**WEST SUSSEX COUNTY COUNCIL  
STRATEGIC PLANNING CONSULTATION**

**SUBJECT: LU/121/17/RES - Approval of reserved matters following outline consent LU/47/11/ for construction of 126 No. dwellings together with internal road network, car parking & landscaping.**

**LOCATION: Land North of, Toddington Lane, C1 & part Parcels B2, B4 & C2, Littlehampton, West Sussex, BN17 7PP.**

GENERAL ARRANGMENT DRAWING (1 OF 2)

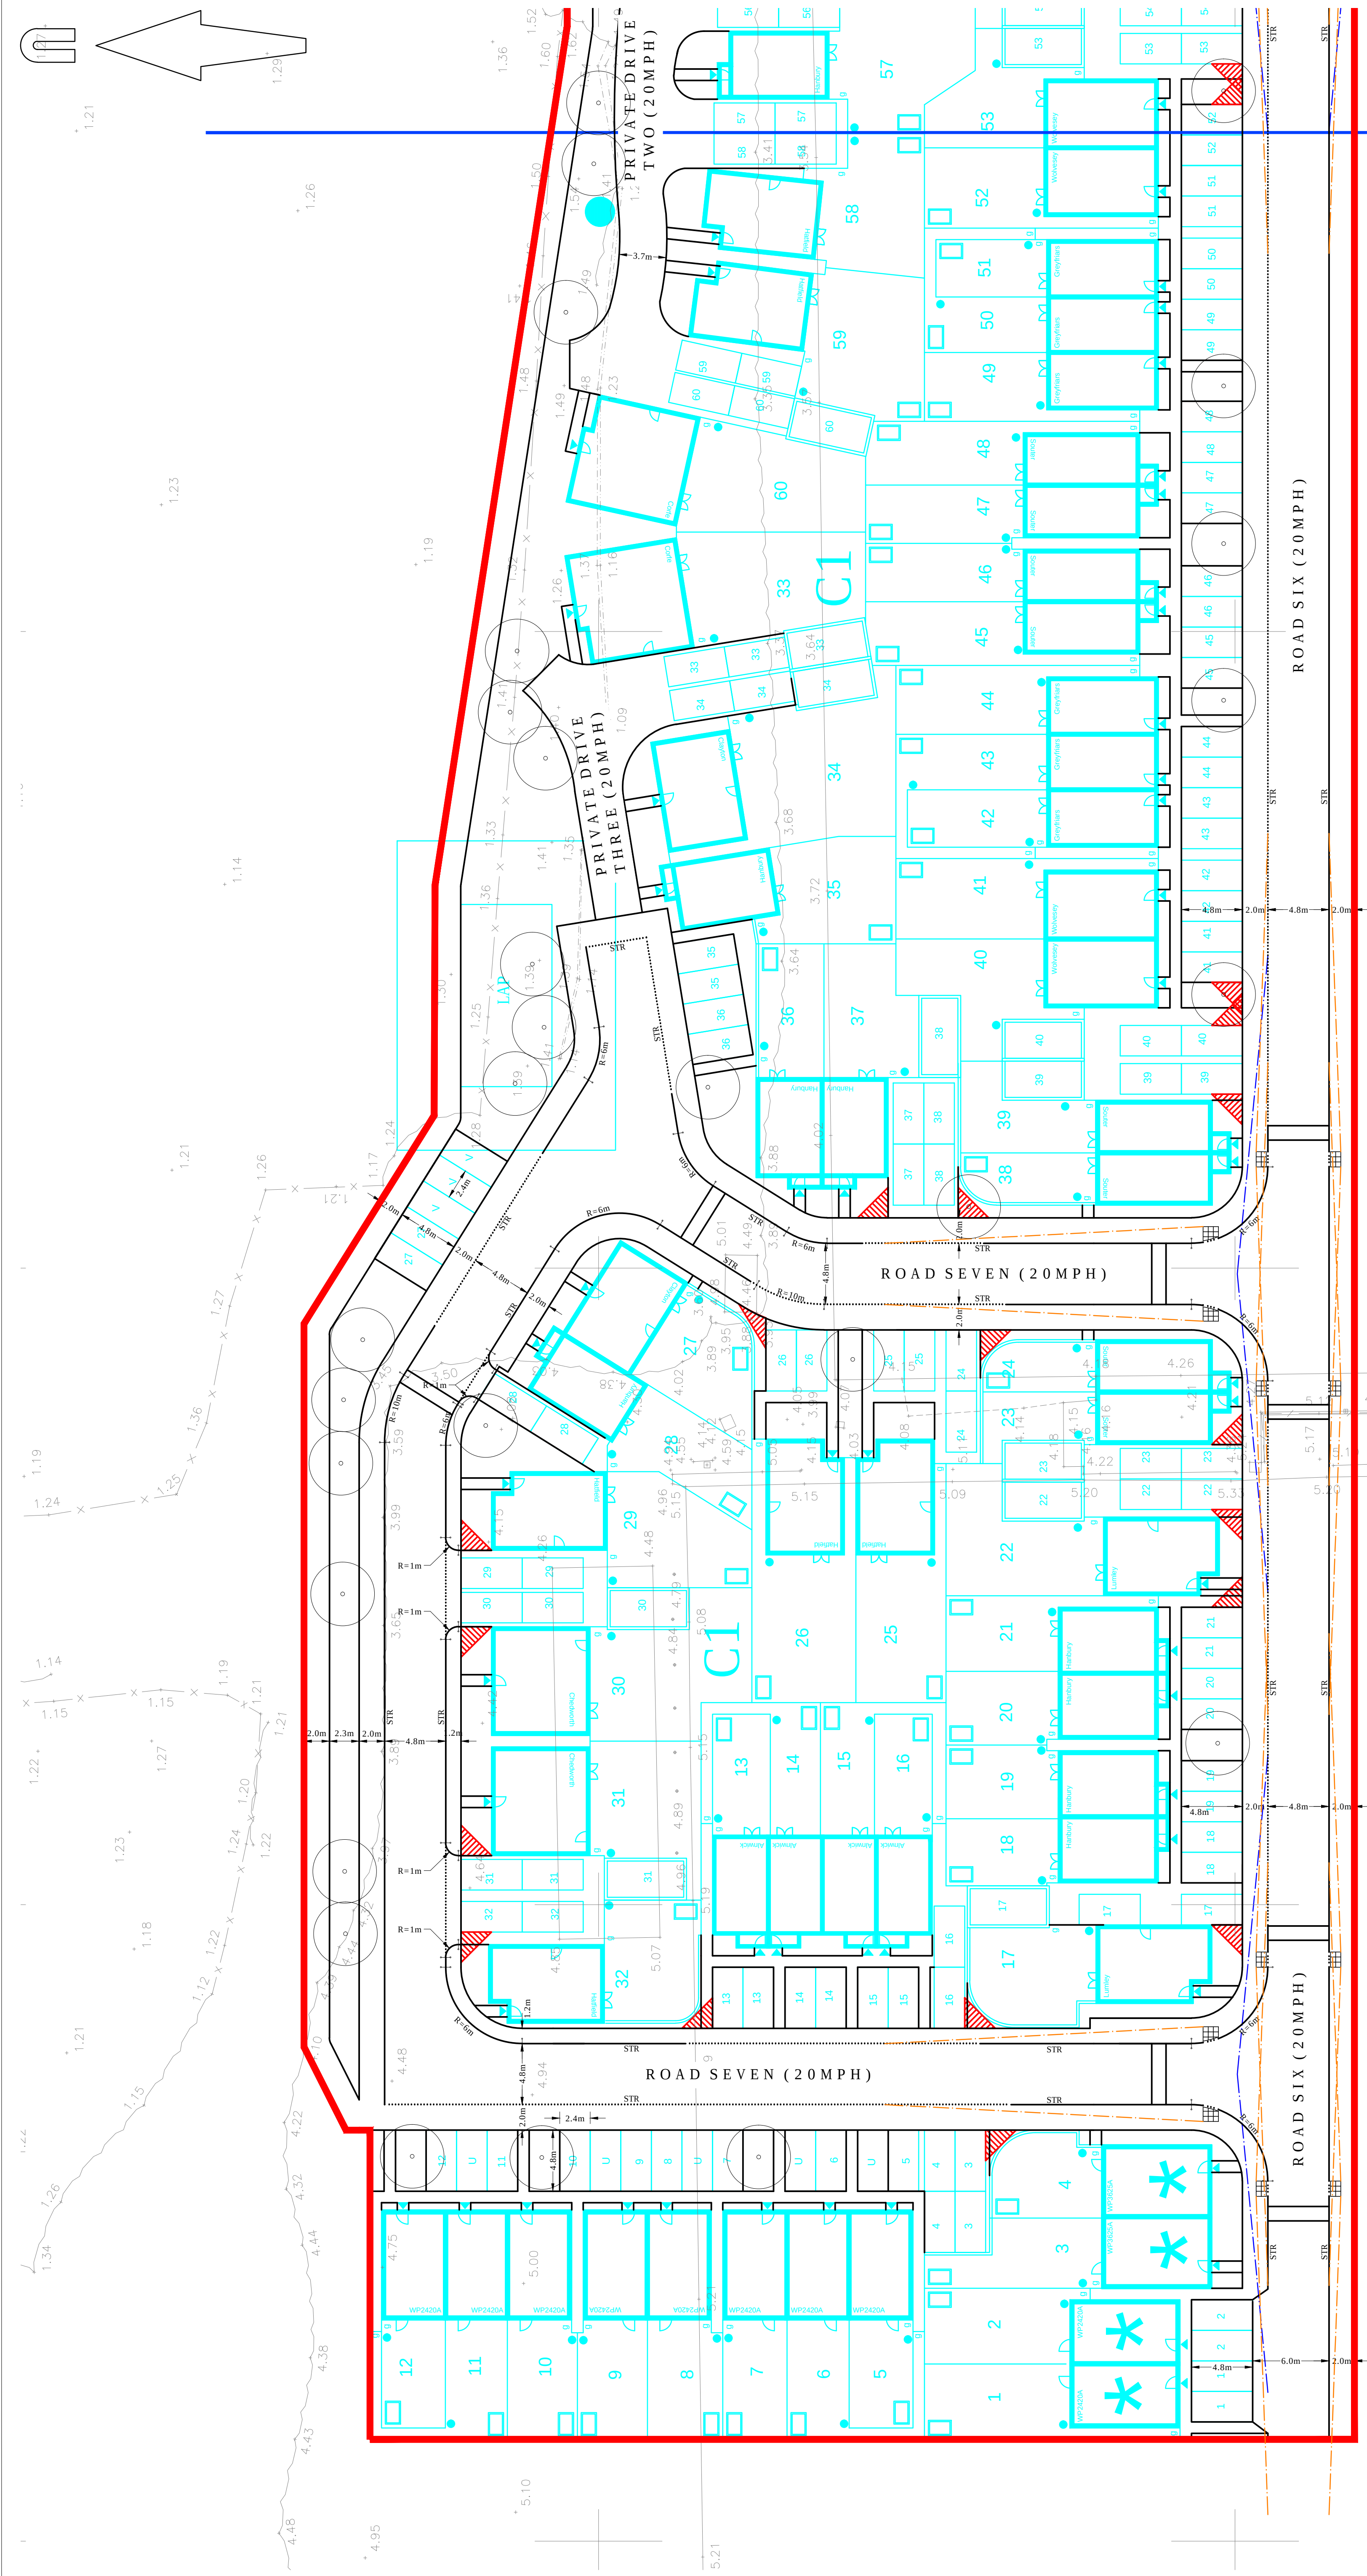
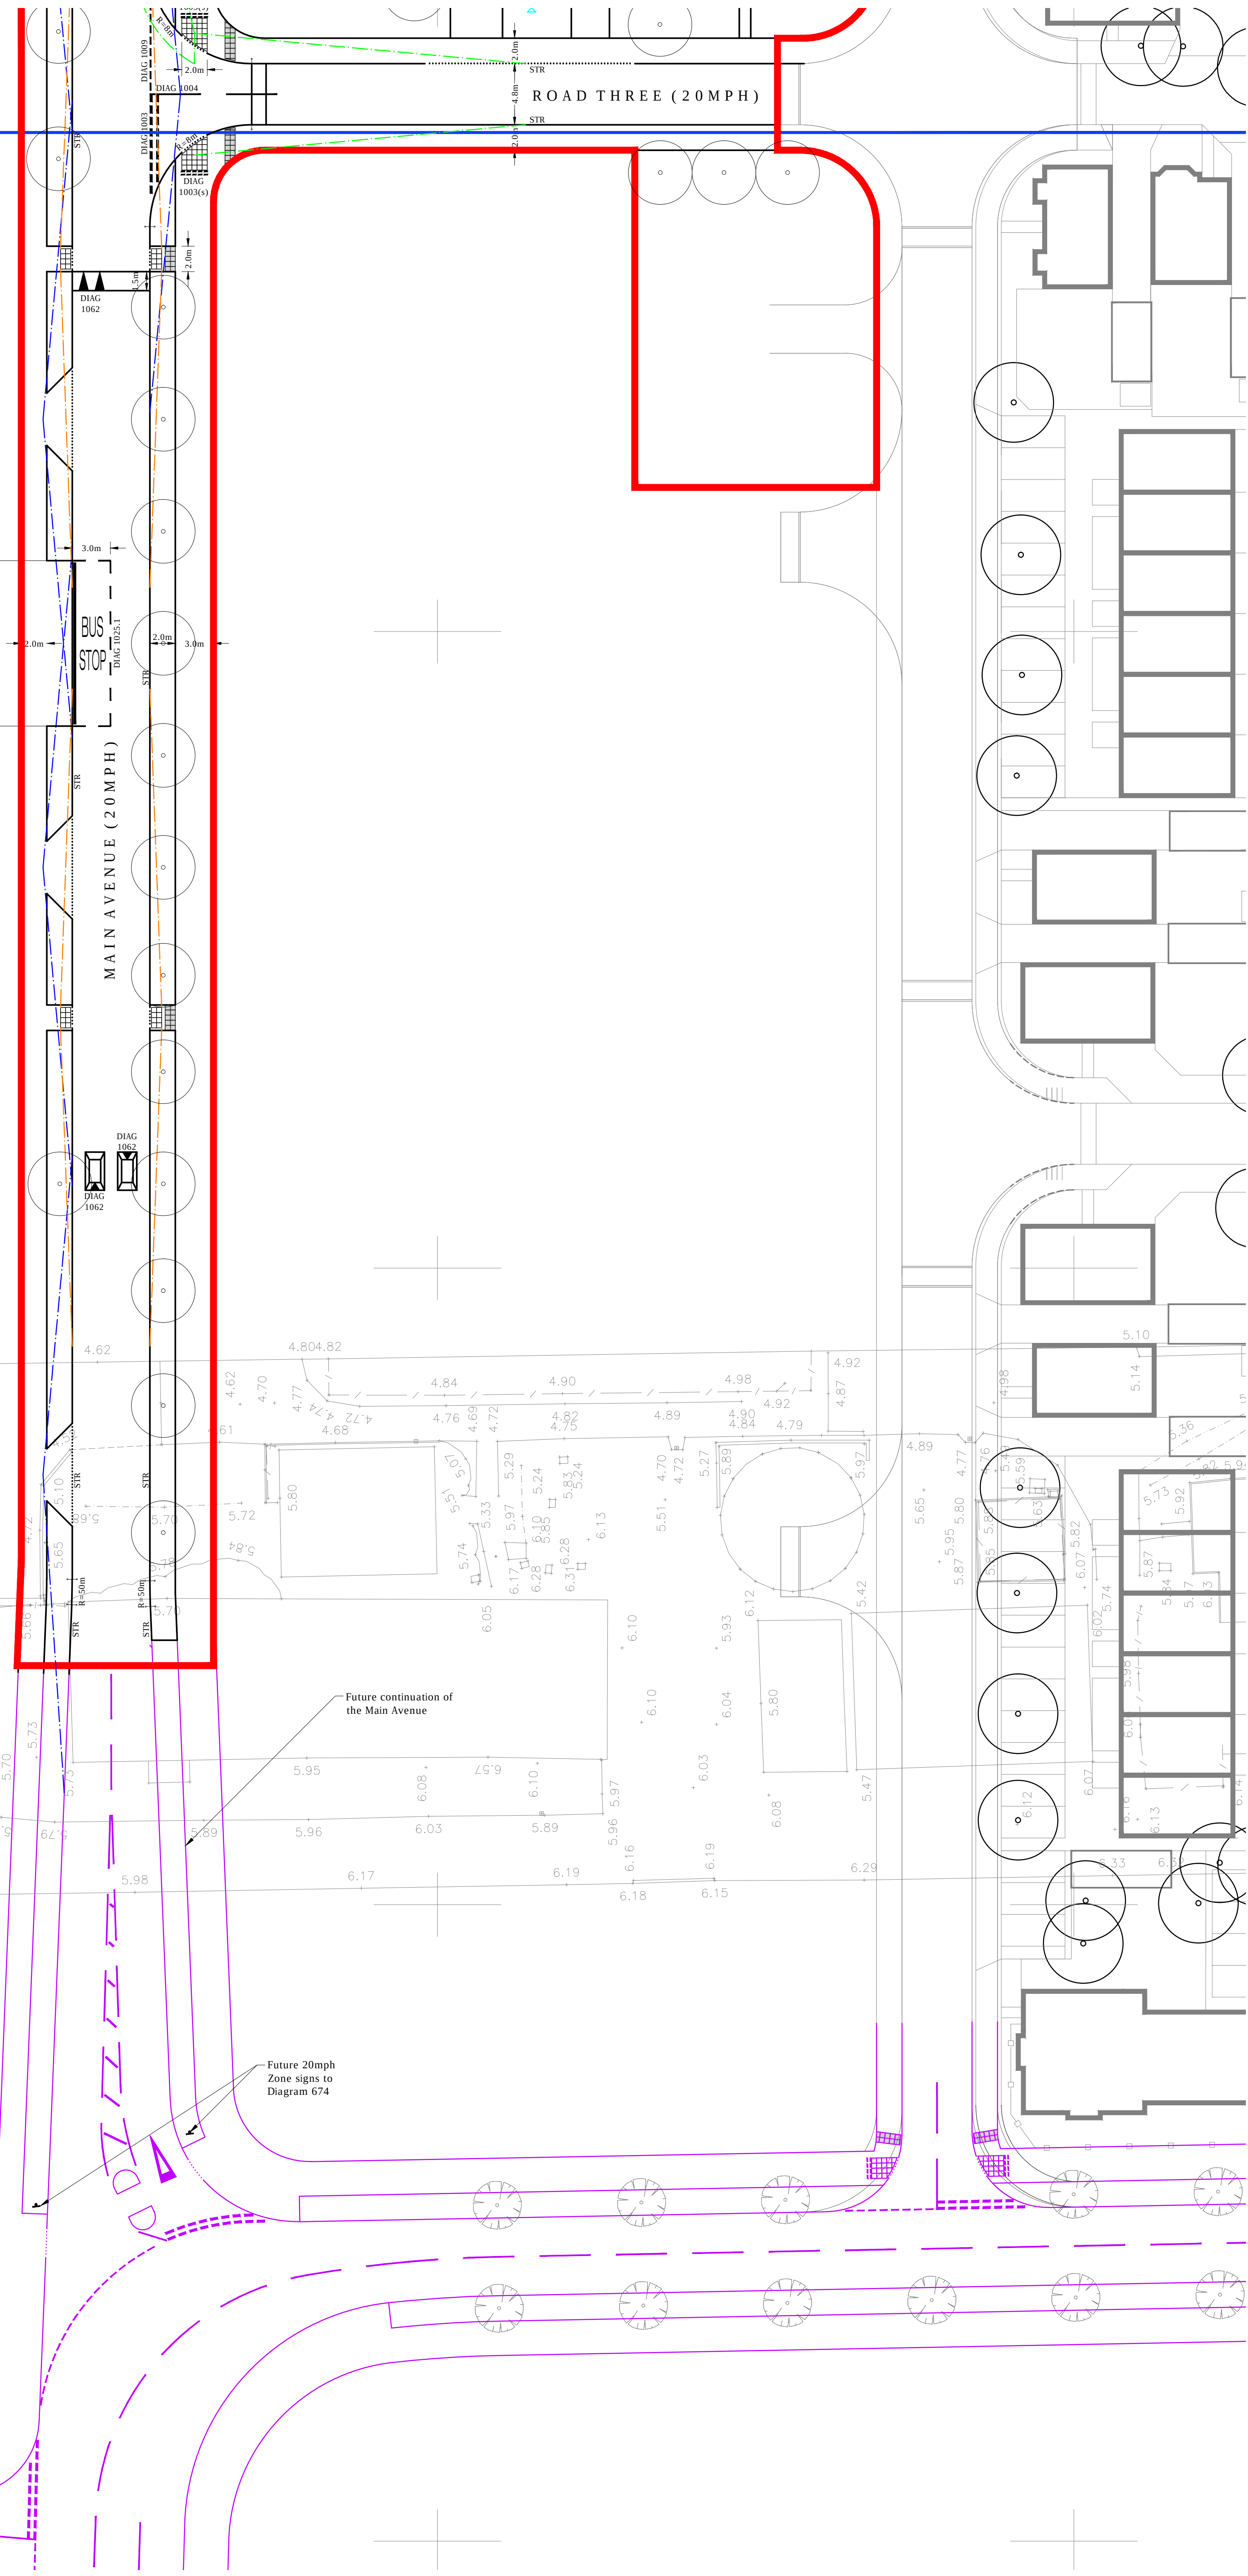
*Surface treatments (roads, footways, landscaping etc.)* – These are shown on Mayer Brown drawings A/PHLITTLE-INT.1/11-1 and A/PHLITTLE-INT.1/11-2 (although landscaping proposals are shown in more detail on White Young Green (WYG) drawing A088461 LA100.dwg). Road surface finishes are shown to be either traditional bituminous carriageways or block paving (private drives and raised table tops at some of the junctions – other than the tabletop adjacent to plots 80 and 95-100). This latter one should be reviewed because the surface treatment is not consistent with the other tables elsewhere in the layout. Also, parts of the layout appear to differ from the illustrative Masterplan Drawing No. 519-GR.L\_002 that forms part of 'sister' S73 planning

application LU/192/15/PL (one example being the length of the main spine road running alongside the proposed commercial area). Applicant to explain this. Further tactile paving needs to be provided at appropriate crossing points. Areas where this needs to be shown are at junctions adjacent to plots 27, 80, 95-100 and for the tactiles shown by plot 126, those moved closer to the junction onto the desire line for crossing and further to enable people to cross the road N-S. All tactiles should be shown on desire lines to aid crossing roads. The foot/cycleway and parking configuration outside plots 81-86 and 87-94 need to be amended as this puts drivers in a position where they will be reversing on or off the main spine road with limited visibility because of lack of footway in front. It also potentially compromises service margin provision. Furthermore, if the intention is to offer this for adoption, private car parking spaces cannot be included in the public highway. Please amend.

*Speed controls etc.* – Raised tabletops are shown at a number of the junctions within the overall layout. In addition to this, speed cushions are shown on certain straight sections of carriageway between the road tables. Traditionally, speed cushions would be used in *existing* situations where traffic speeds are shown to exceed the prescribed speed limit, whereas this is a new situation. As such, the applicant should provide evidence and consideration of alternatives for speed control for the roads where cushions are shown. These should be submitted to the LPA and CHA to consider. It should also be demonstrated how anything proposed will control traffic speeds to the speed limit proposed and how they would be suitable for the road users expected to use them.

*Visibility splays* – Need to be appropriately shown in accordance with relevant guidance at all junctions and where driveways join carriageways (including consideration of landscaping and demonstration that planting etc. does not obstruct visibility splays). Some are shown but not all. Please amend.
